Memorandum

Re: Allaso Louisiana Site Plan – DRB Comment Responses (PR-2021-006238)

This memo outlines the responses and changes made to the site plan for the Allaso Louisiana project based on the updated and remaining comments received and reviewed at the January 12, 2022 DRB meeting.

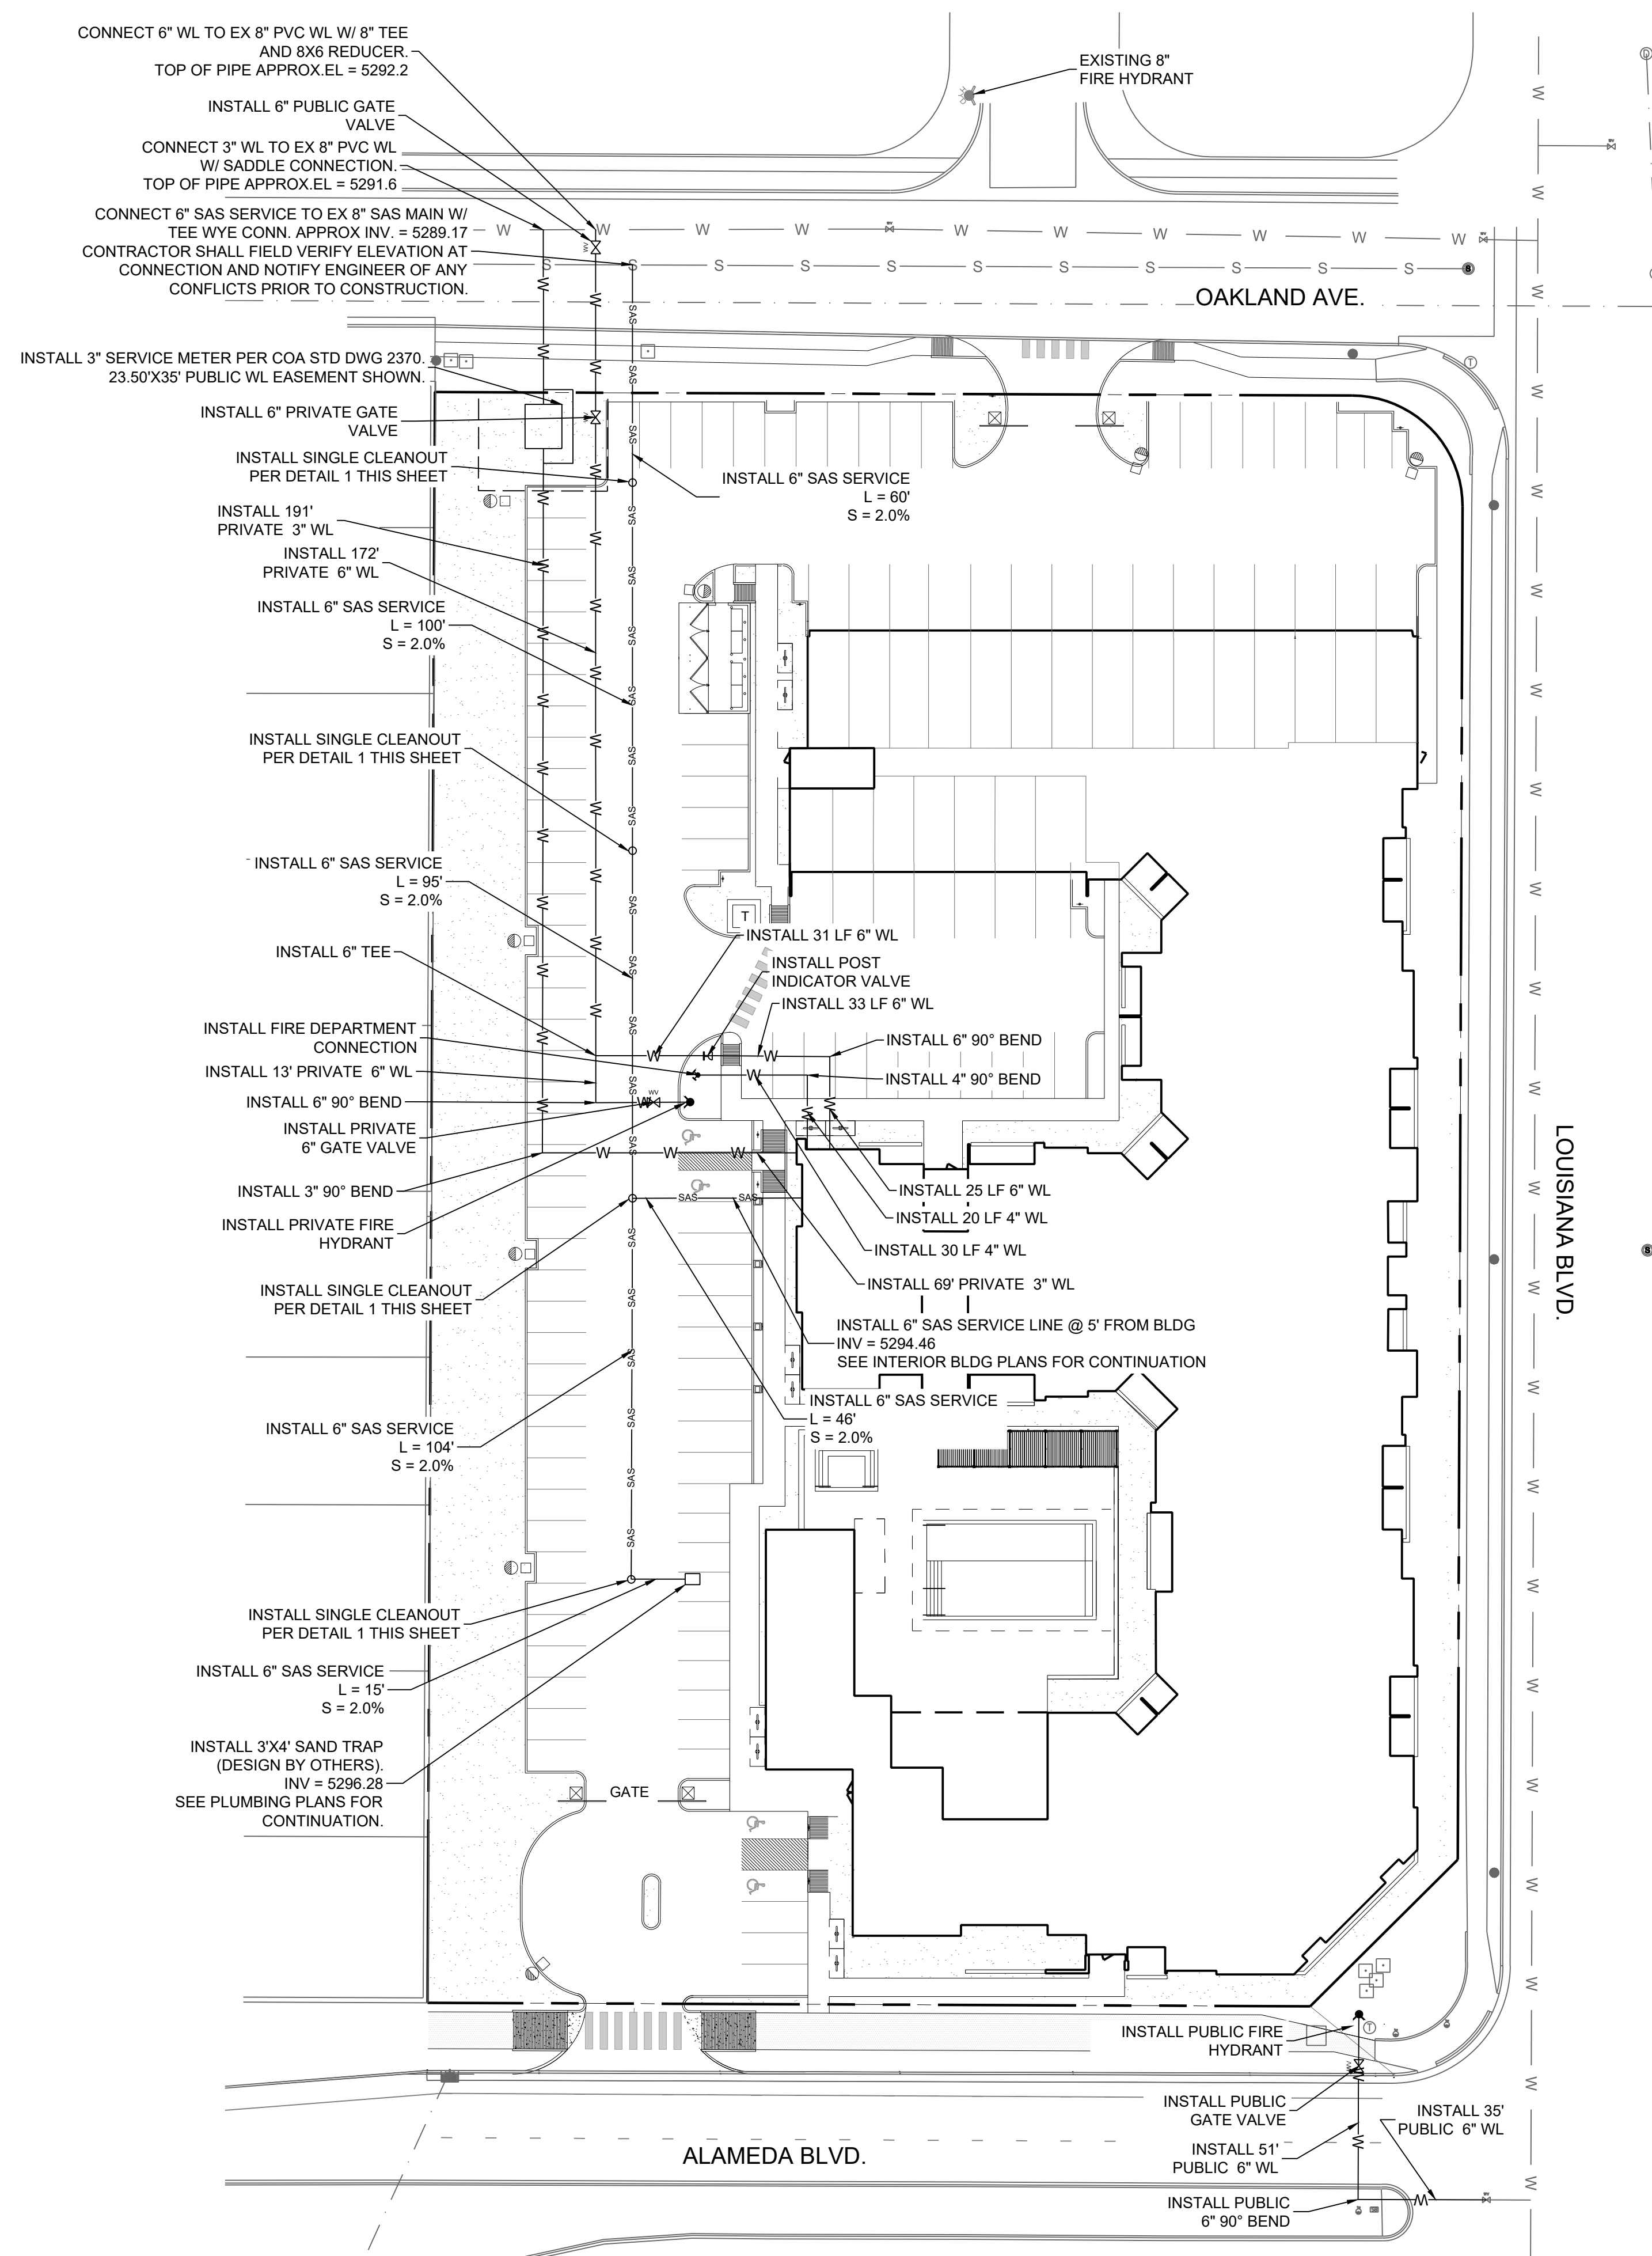
1. Hydrology did receive the submittal on 11/11/2021 (C18D085). Hydrology had a minor comment about Stormwater Quality Volume. Once the Engineer fixes the Grading & Drainage Plan, Hydrology will approve it.
 - a. ***The grading and drainage plan has been updated to account for the required Stormwater Quality Volume.***
